From: [REDACTED]
Sent: 18 December 2017 14:31
To: Zac Denton
Subject: Re: FP/257/17/T

This email is regarding your current application for tree consent works at the Open Space bordered by Copeland Road and The Ridgeway.

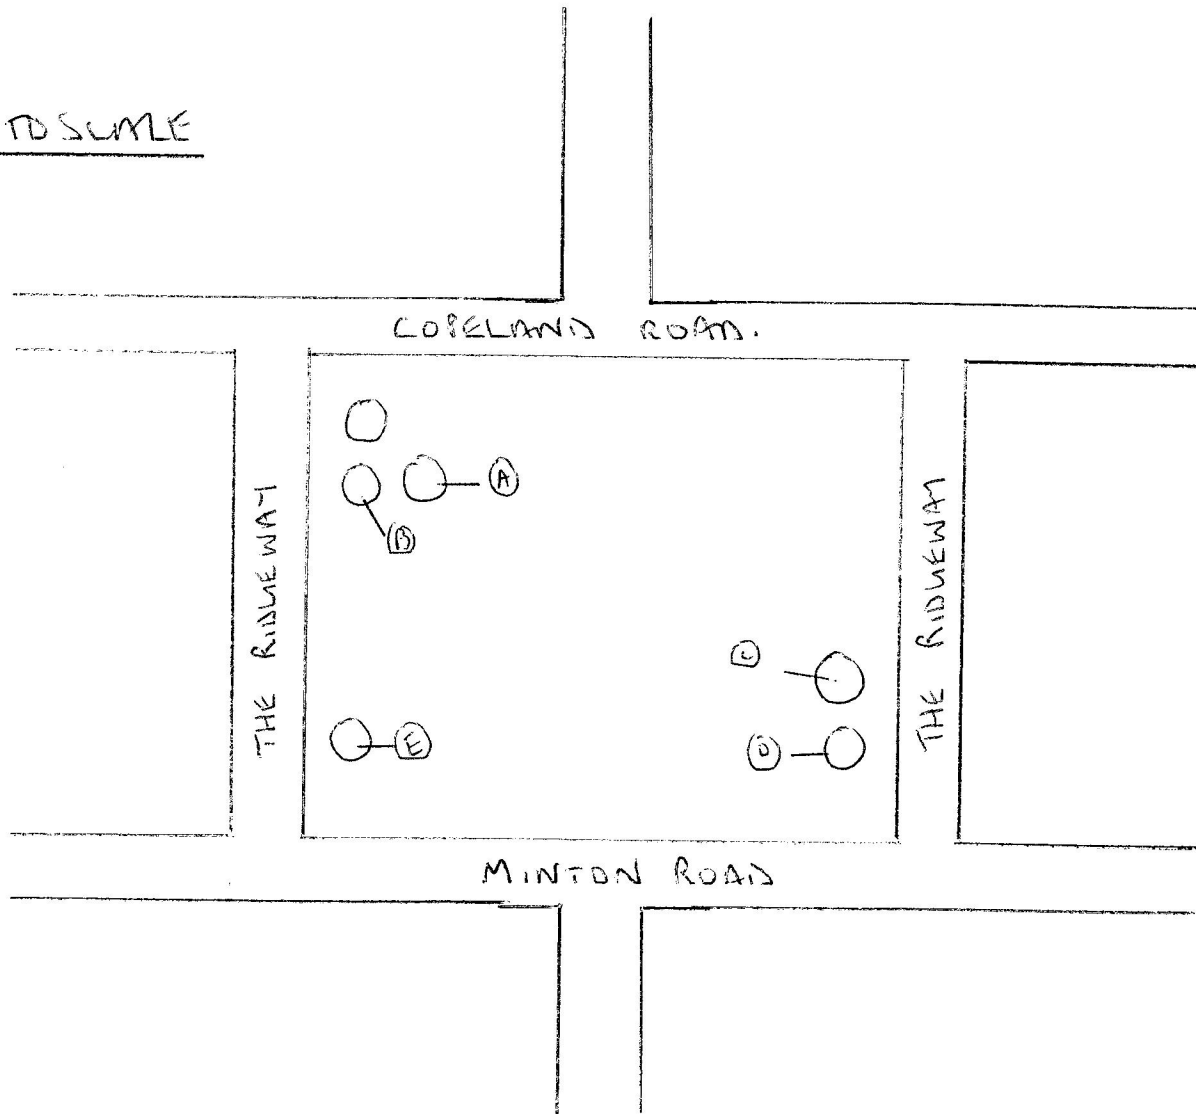
As it stands, the application is set to be refused, as the Arboriculturalist believes that the works to the Grey Poplar are excessive.

Yes please zac can we go with that! 🍷

If you would like, I can remove the 4m height reduction and 2m spread reduction from the application. This would allow you to perform a 2m height reduction and 1m spread reduction.
